Response to Section 51 advice for Thanet Extension

Thanet Extension Offshore Wind Farm

Appendix 1 to Response to Section 51 Advice:
Section 44 consultees

THANET EXTENSION OFFSHORE WIND FARM

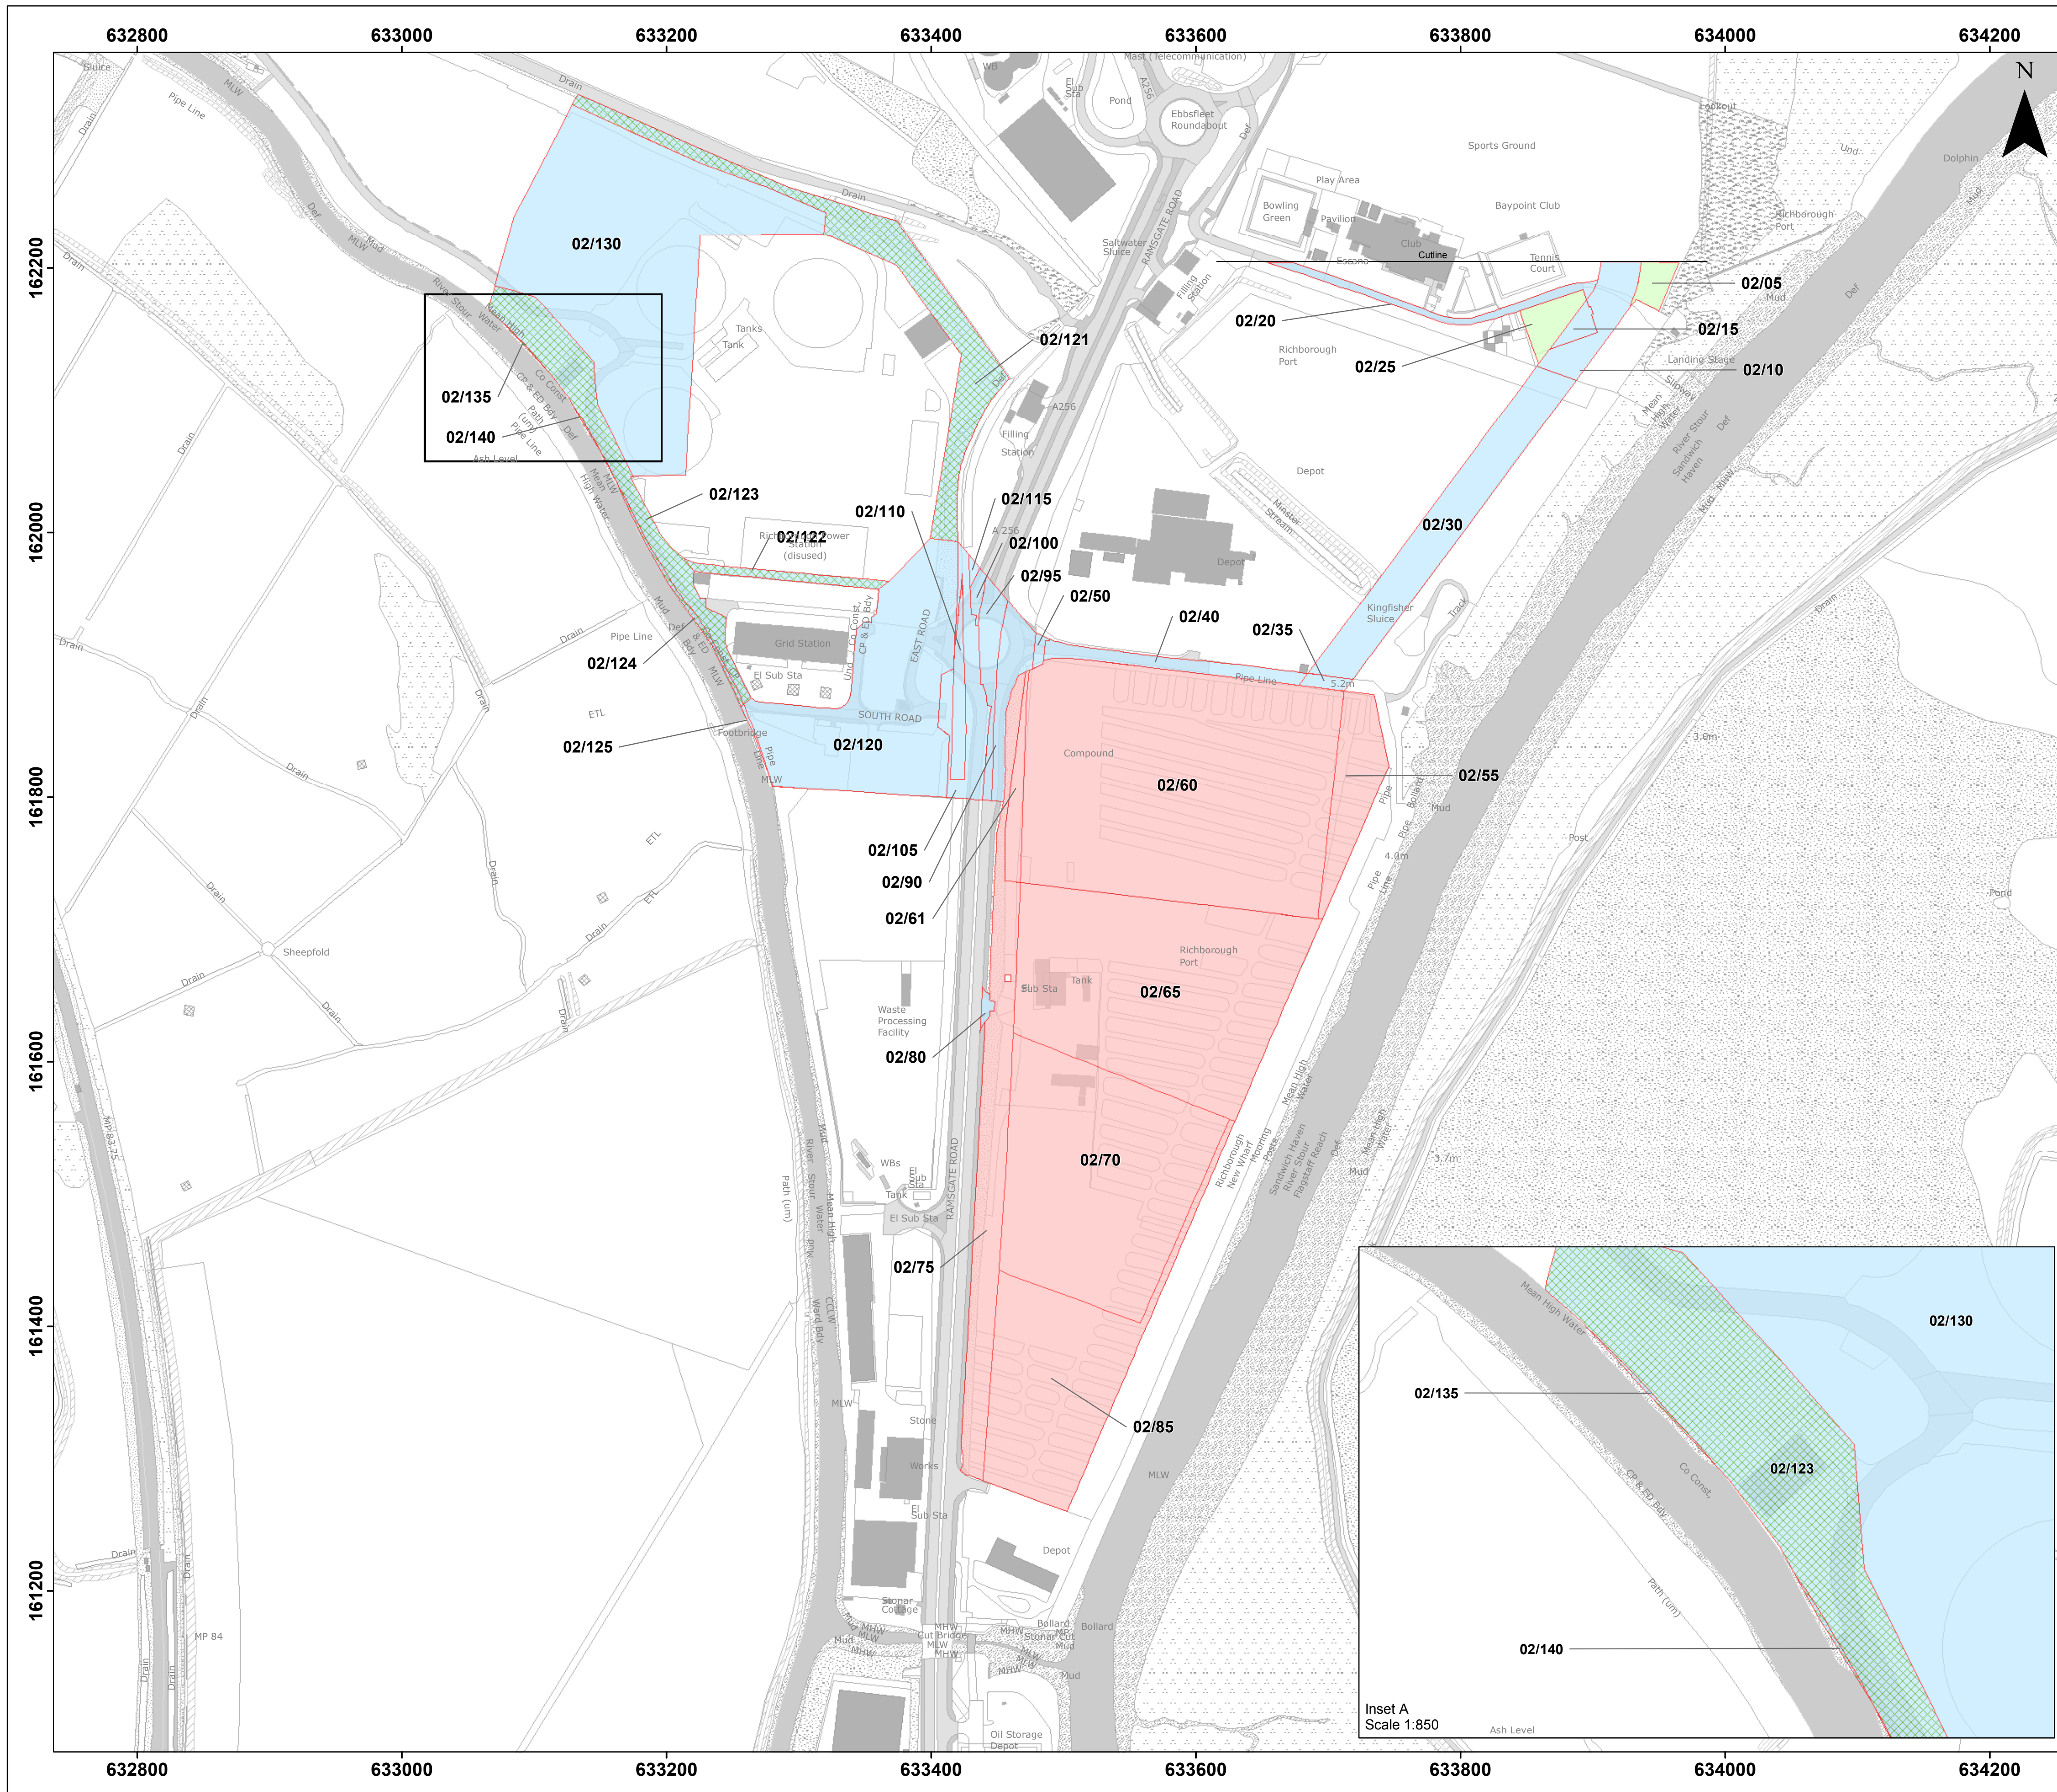
In the legend 'Cable route options' does not describe what rights are being sought.	The legend has been amended to read 'Cable route options – Permanent acquisition of new rights'.
No landmarks or road names are identified on the land plans	This has been updated on Land Plans and specific land mark names, where needed, have been added to the OS mapping.
The scale is not in compliance with Regulation 5(4A) of the APFP Regulations, for the onshore plan sheet 0.	This sheet has been changed to 1:2,500.
